CM/8/22/DOC

Kents Farm House Brookpit Lane Climping BN17 5QU

Approval of details reserved by condition imposed under ref CM/51/20/L relating to Condition No 1 - schedule of materials and finishes to be used for external walls and roofs.

Drawing Title
**WINDOW AND DOOR
DETAILS**

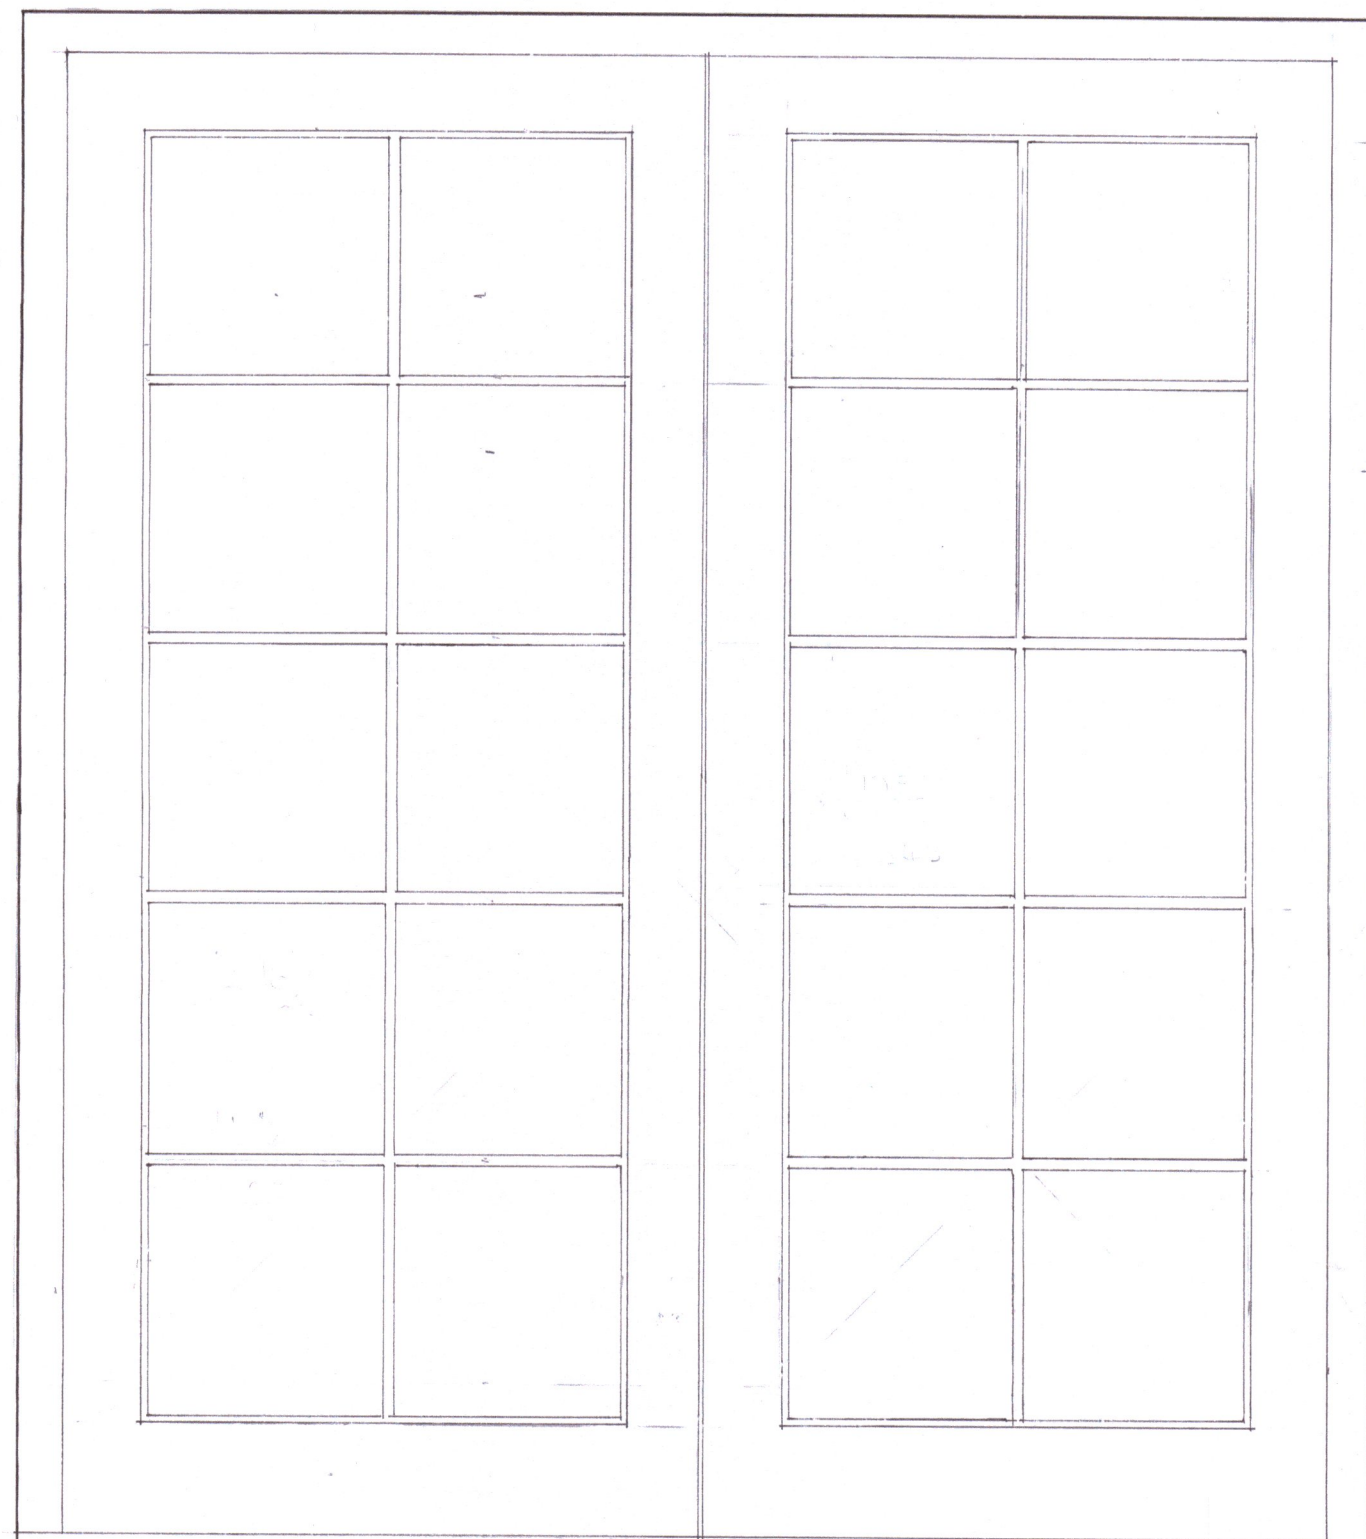
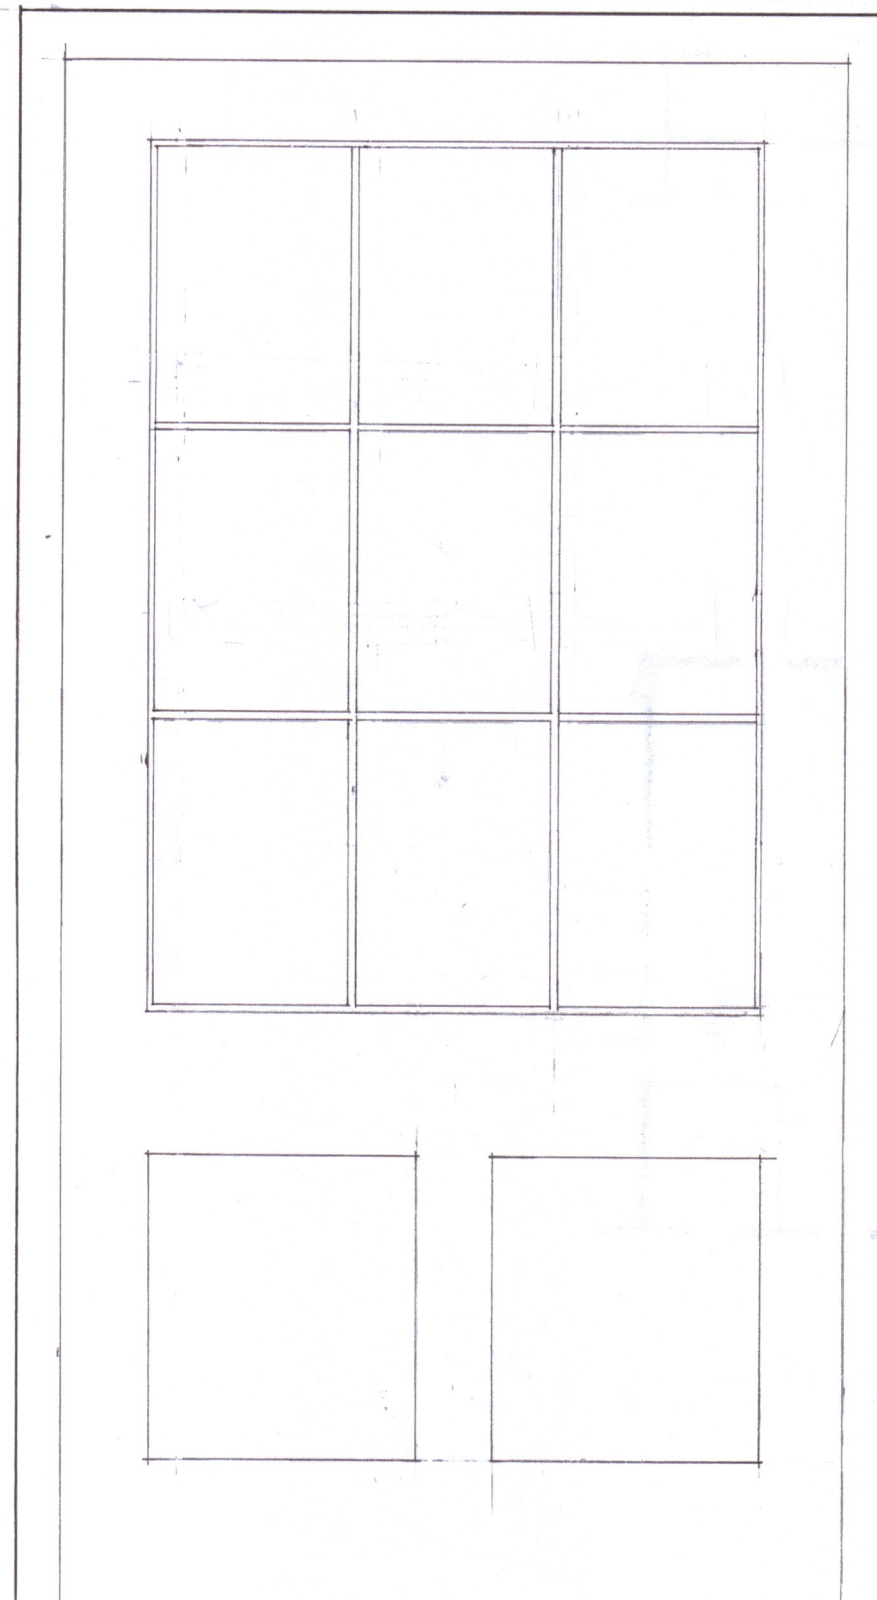
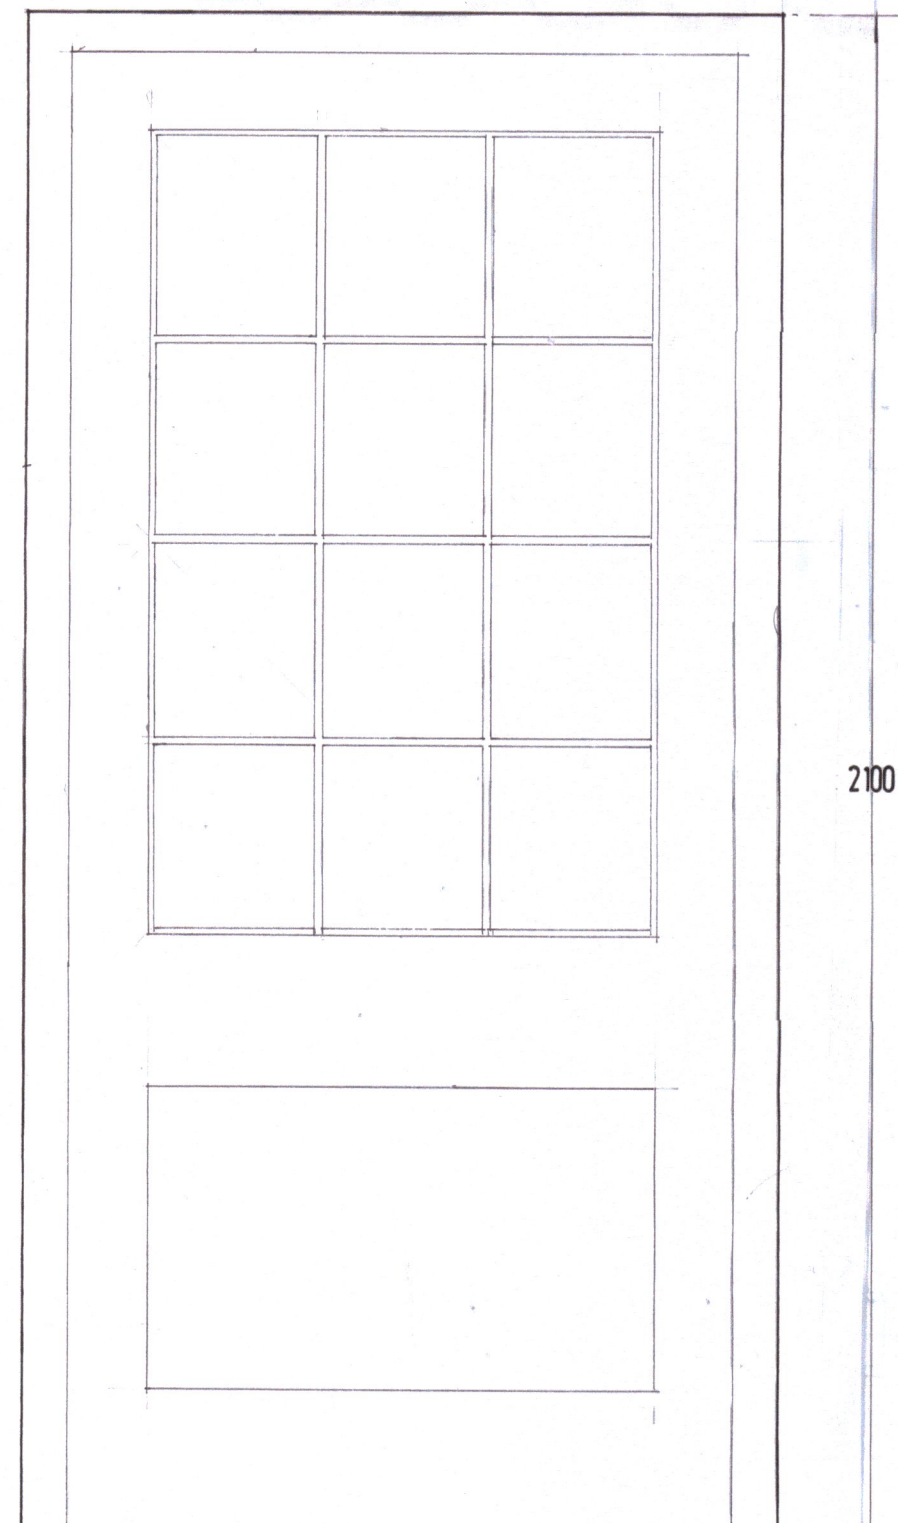
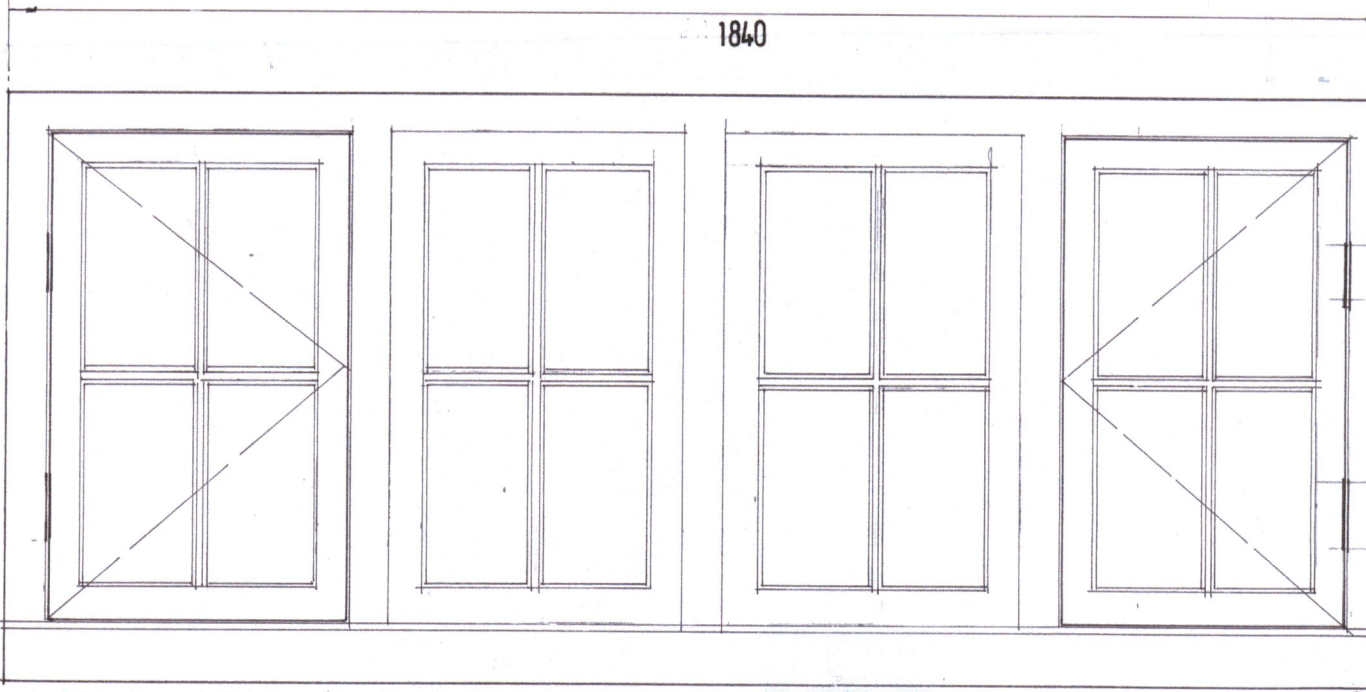
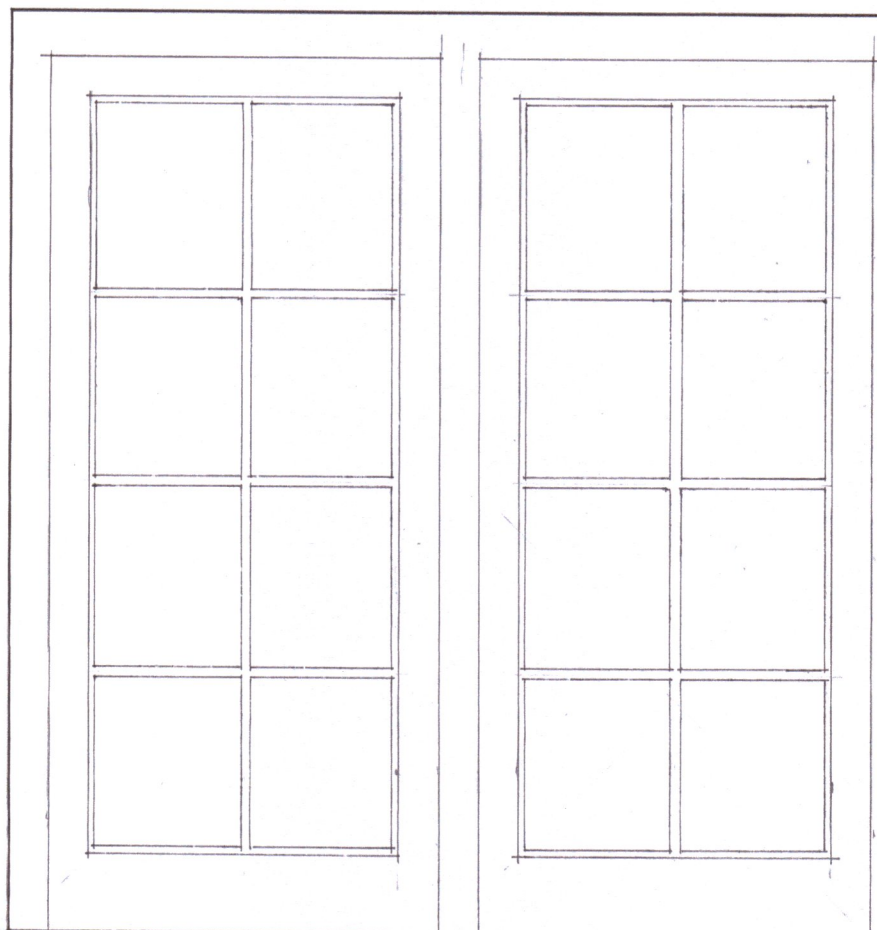
As noted in previous comments on DOC applications, and unfortunately, also noted here as well, the drawings of the windows identify that 'standard' (24mm) double glazed units are to be used for the new/replacement windows. As previously noted, this is not acceptable. If double glazing is to be accepted, it will have to be the slimmer heritage style. However, the cover letter contradicts the plans stating the windows will be single glazed. Please can the glazing be confirmed!

BOILER ROOM
GARAGE, OIL TANKS

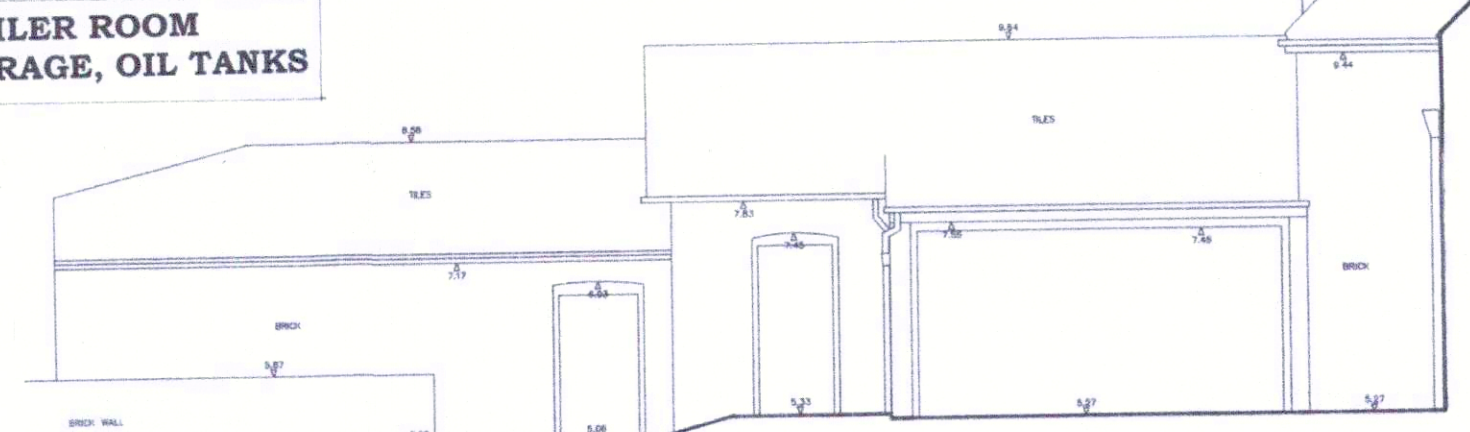
I also note a reference to the fact that the boiler has been removed to an 'outbuilding with no listed building significance'. Please can the location be confirmed as the outbuilding may still be classed as curtilage listed?
